Letter No. A1/44442/2000

Sub: CMDA - Planning permission - Construction
of Ground + 1 floors residential building
at Plot No.79B, Annai Therasa Nagar in
S.No.51/16 and 51/17 of Puzhuthivakkam
village - Development charges and other
charges to be remitted - Reg.

PLAN SHOWING THE PROPOSED RESIDENTIAL BUILDING AT PLOT NO. 79-B IN SURVEY NO. 51/16/51/17 OF ANNAI THERESA NAGAR PHASE II PUZHUTHIVAKKAM HAMLET OF MADIPAKKAM VILLAGE, TAMBARAM TALUK, KANCHIPURAM DISTRICT.
 SCALE 1" = 8'0" (1:100)
 LAYOUT & PPD IN PPD/LO 36/95

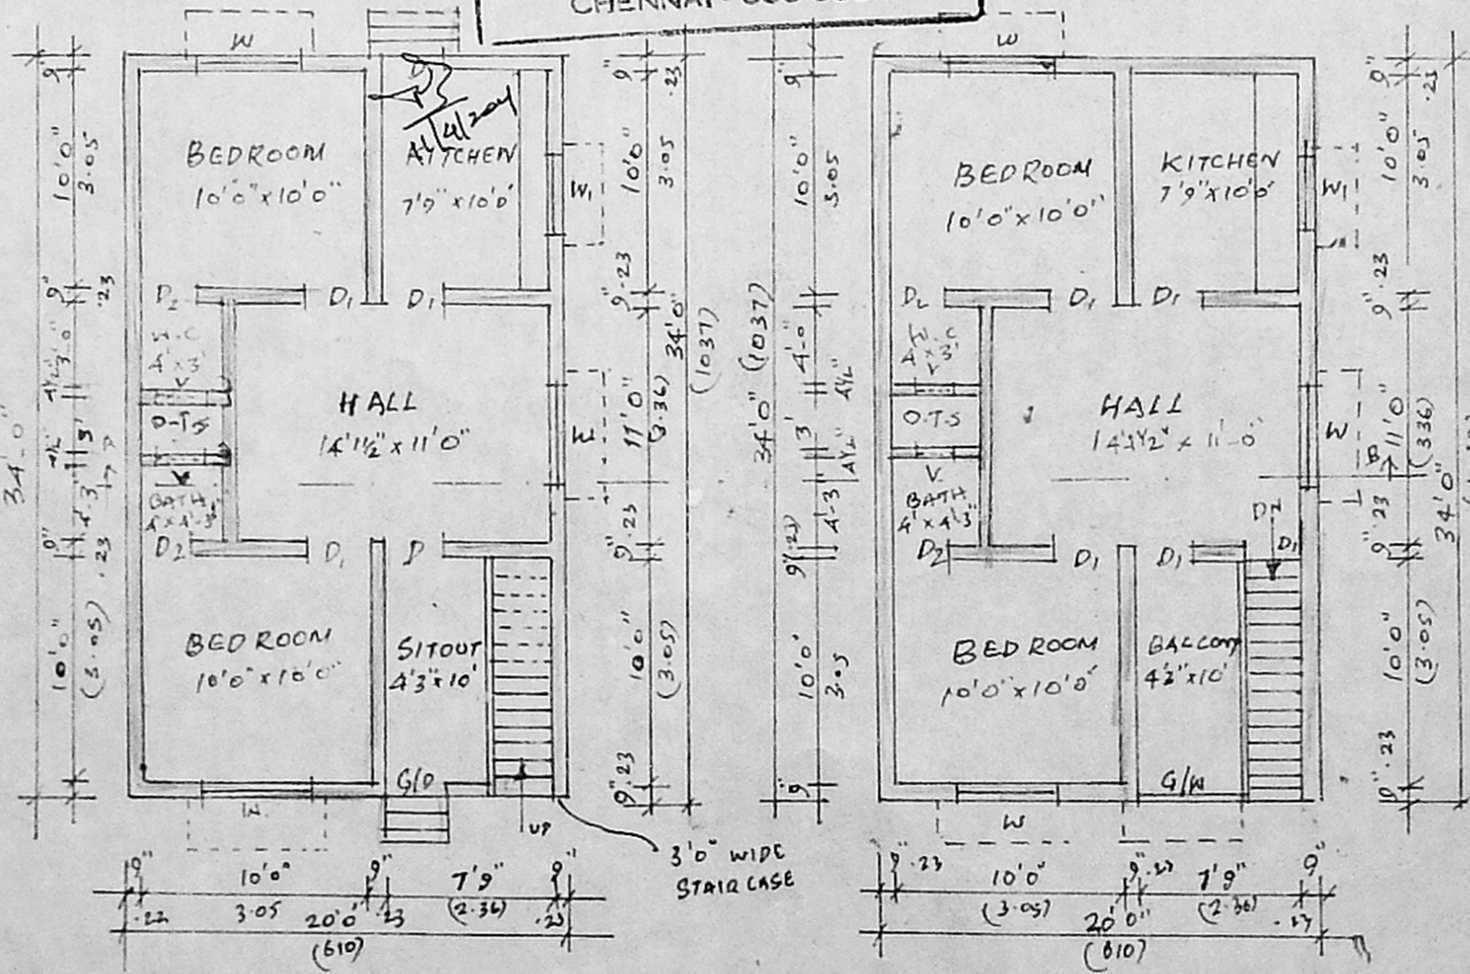
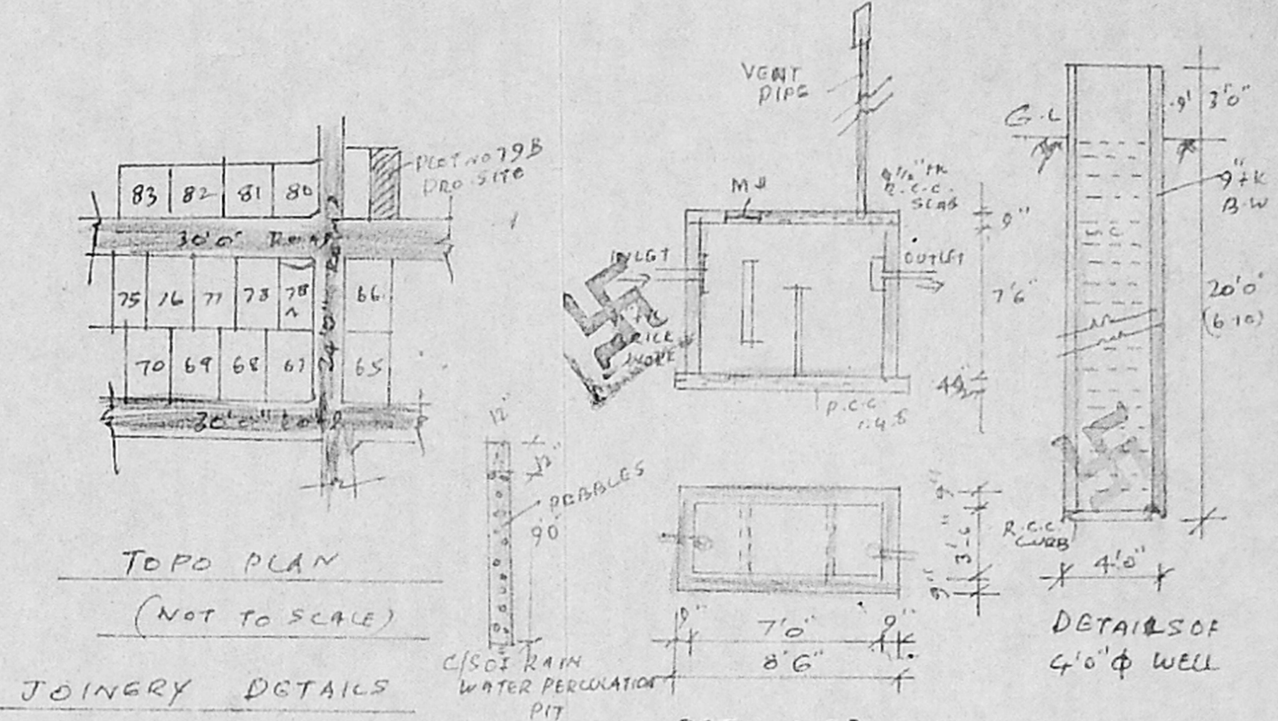
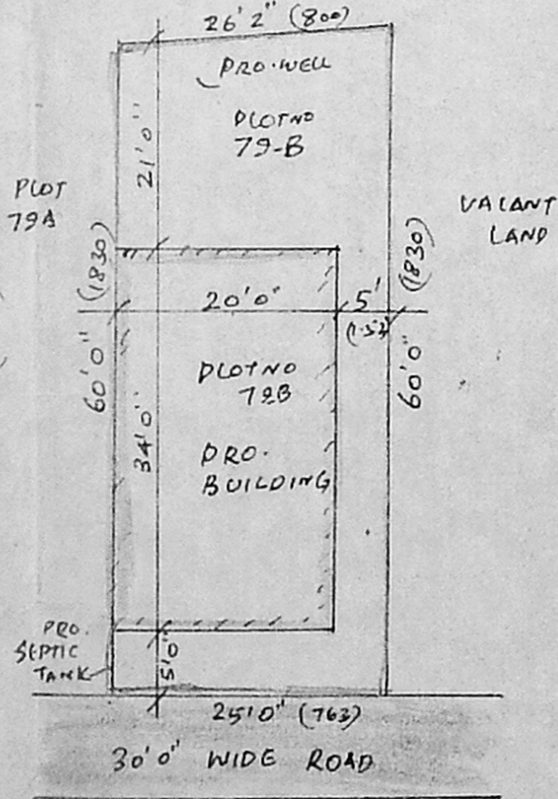
- a) Rain water conservation regulations stipulated by CMDA should be adhered to strictly.
- b) Five copies of revised plan without ventilation on western side and making suitable arrangement for ventilation to toilet.
